Our Ref: 18COLL02: NVD/JT
SSD Ref: 9536
NSW RFS ref: D18/6890

**Re: Bushfire conditions
Wyong Hospital Expansion, Hamlyn Terrace**

Travers bushfire & Ecology are responding to the NSW Rural Fire Service (RFS) submission's made in relation to SSD 9536, and set out in its letter dated 4th March 2019, and in particular, Conditions 6, 7 & 8 which state the following:

DRAWING TITLE  
**SITE PLAN - PROPOSED**

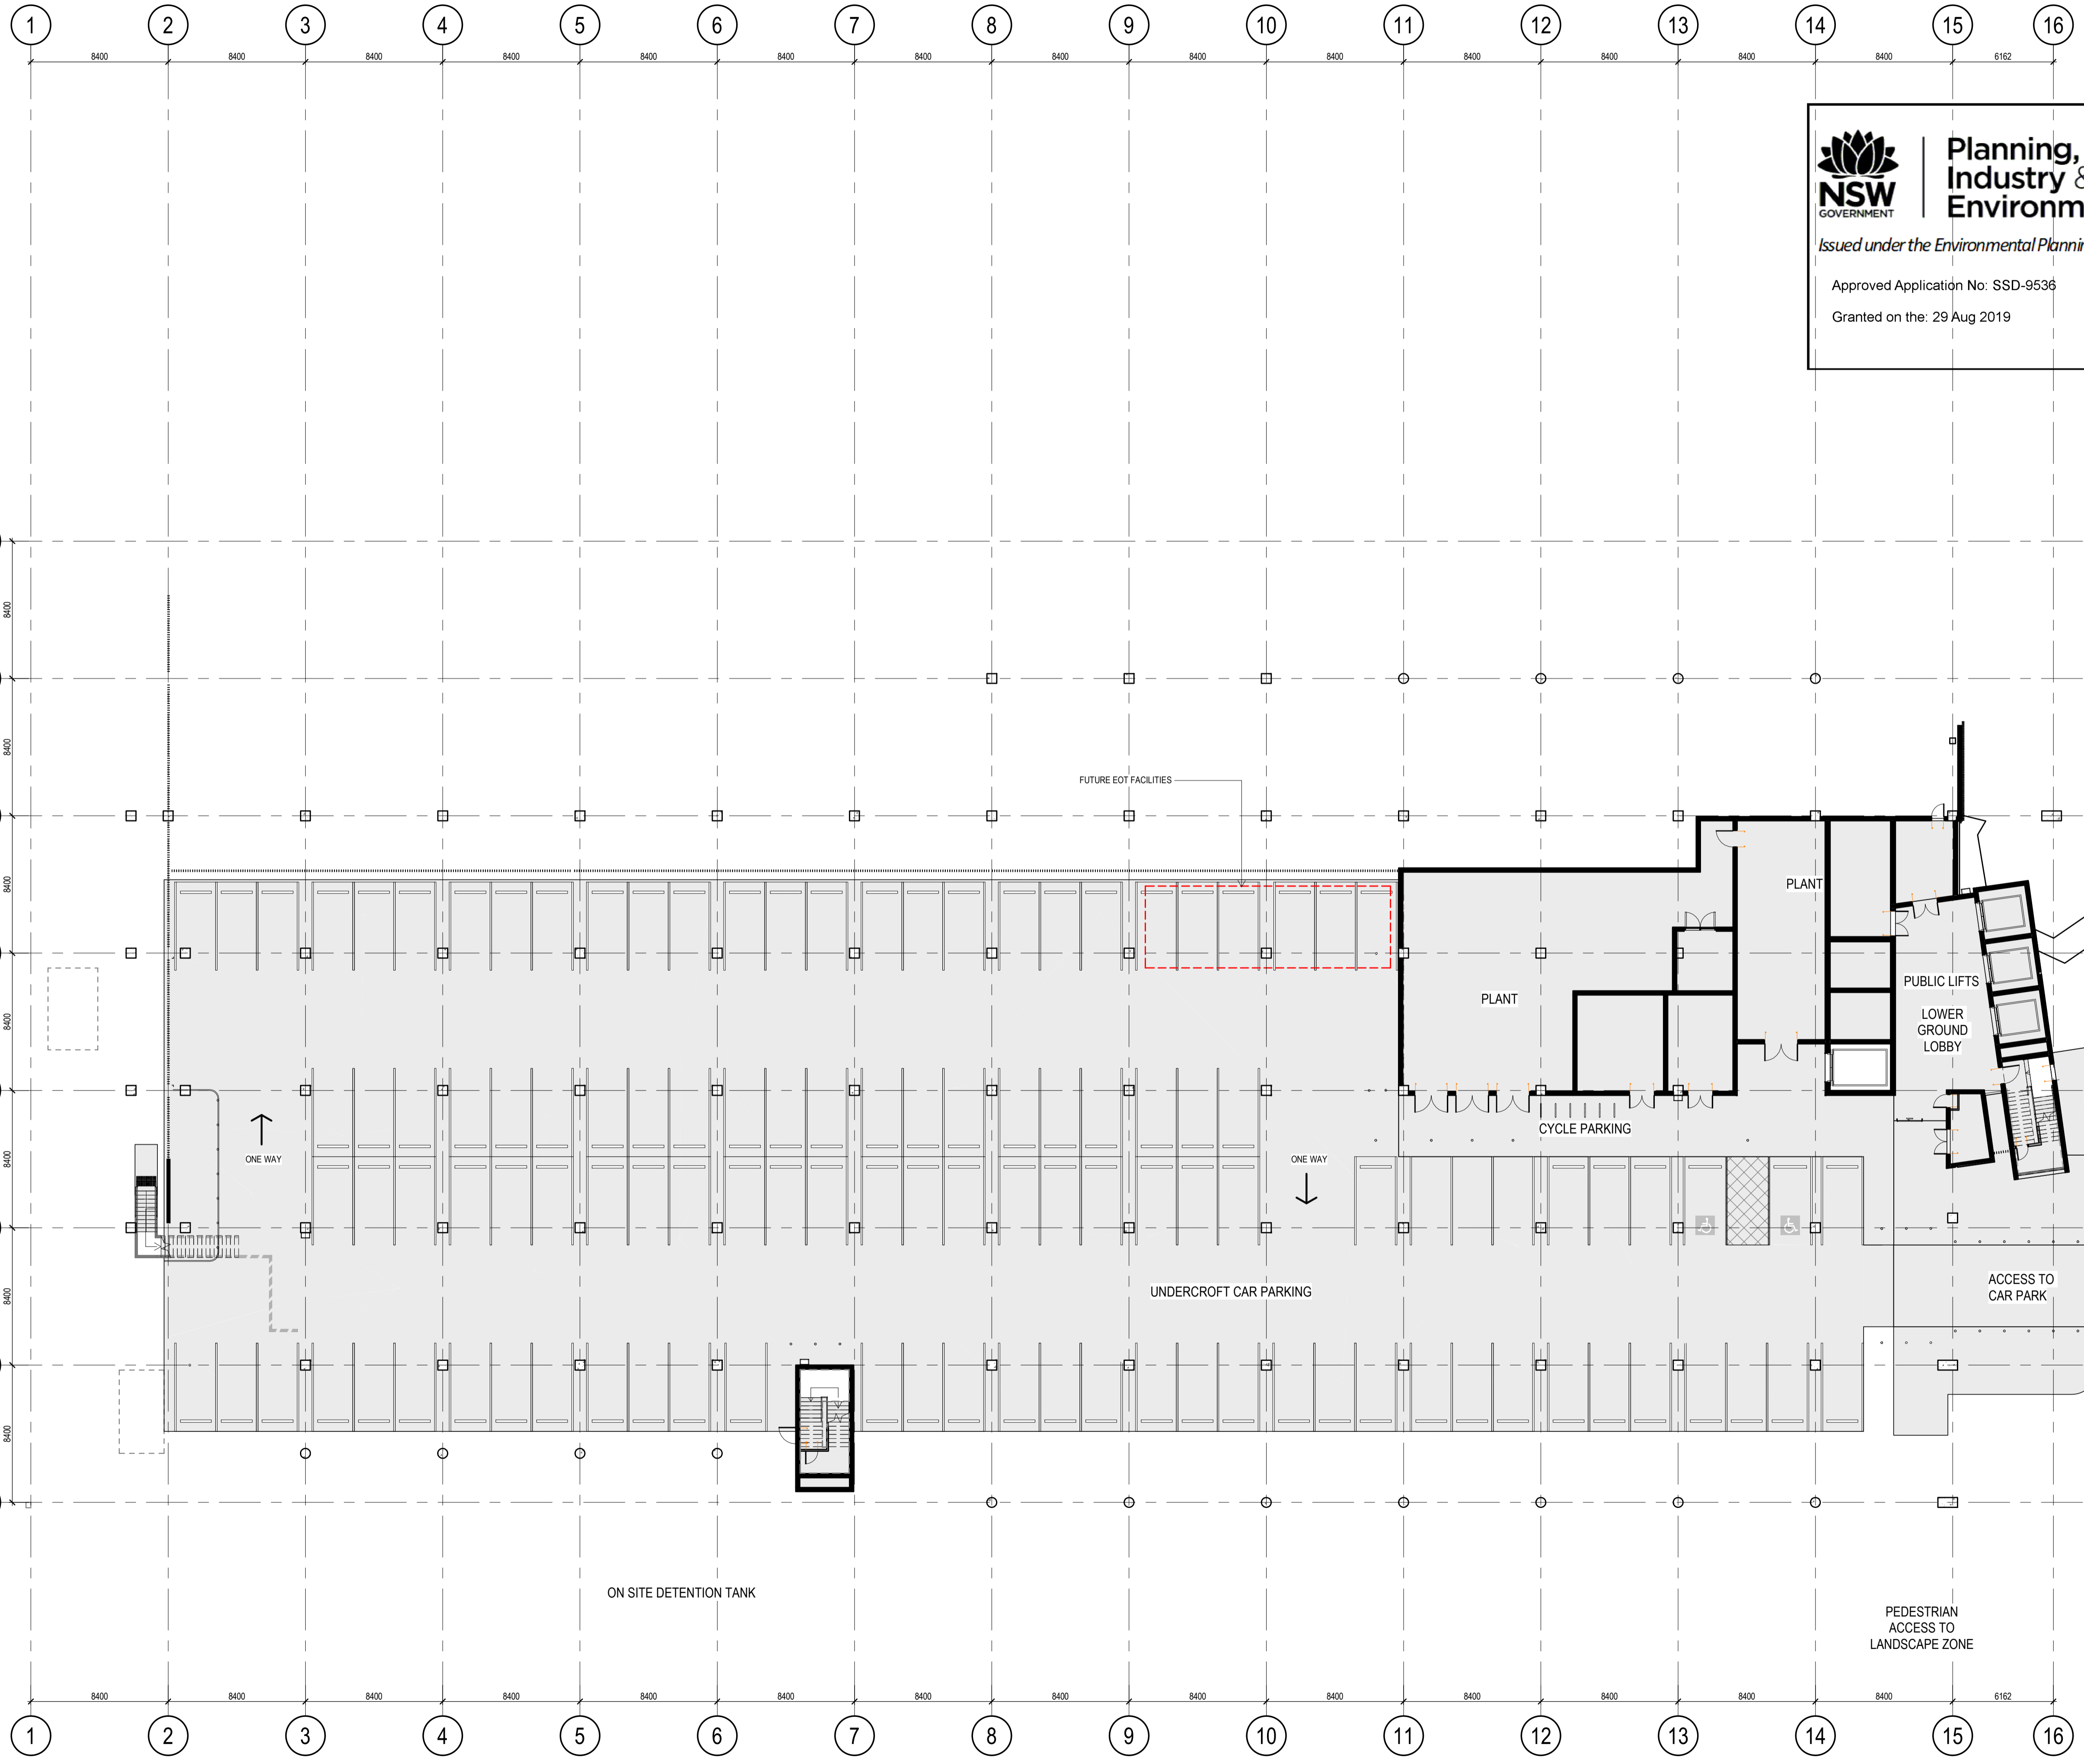
8. A minimum 1.8m high radiant heat shield made of non-combustible materials shall be constructed adjacent to the hazard to the south and west. All posts and rails shall be constructed of steel. The bottom of the fence is to be in direct contact with the finished ground level or plinth. The location of the radiant heat shield shall be as generally shown in Schedule 1 – Bushfire Protection measures of the submitted bushfire report prepared by Travers bushfire & ecology (dated November 2018, Reference 18COLL02).

The most recent consultation with RFS (Craig Casey) occurred via email (dated 15/5/19 and attached) and phone correspondence (20/5/19) to discuss and agree the removal of the fence (Condition 8) based on the increased construction standards and location of building entry and exit points.

Based on the revised calculations undertaken by *Travers bushfire & ecology* the removal of the fence results in the building being exposed to radiant heat levels of 10.35kW/m^2 and only an increase in radiant heat by 0.35kW/m^2 . Whilst this is over the 10kW/m^2 (threshold required for safety of occupants entering or exiting a building) there are no exits or entries to the building with this area and therefore the proposal will comply with the performance criteria outlined in PBP.

As a result the NSW RFS have agreed (via telephone conversation 20/5/19) that Condition 8 can be removed and the requirement for the fence is no longer applicable. This is based on the increased building construction (in compliance with Condition 6 & 7) which will provide additional redundancy in the overall design. On this basis NSW Health accepts the recommended conditions 6 & 7.
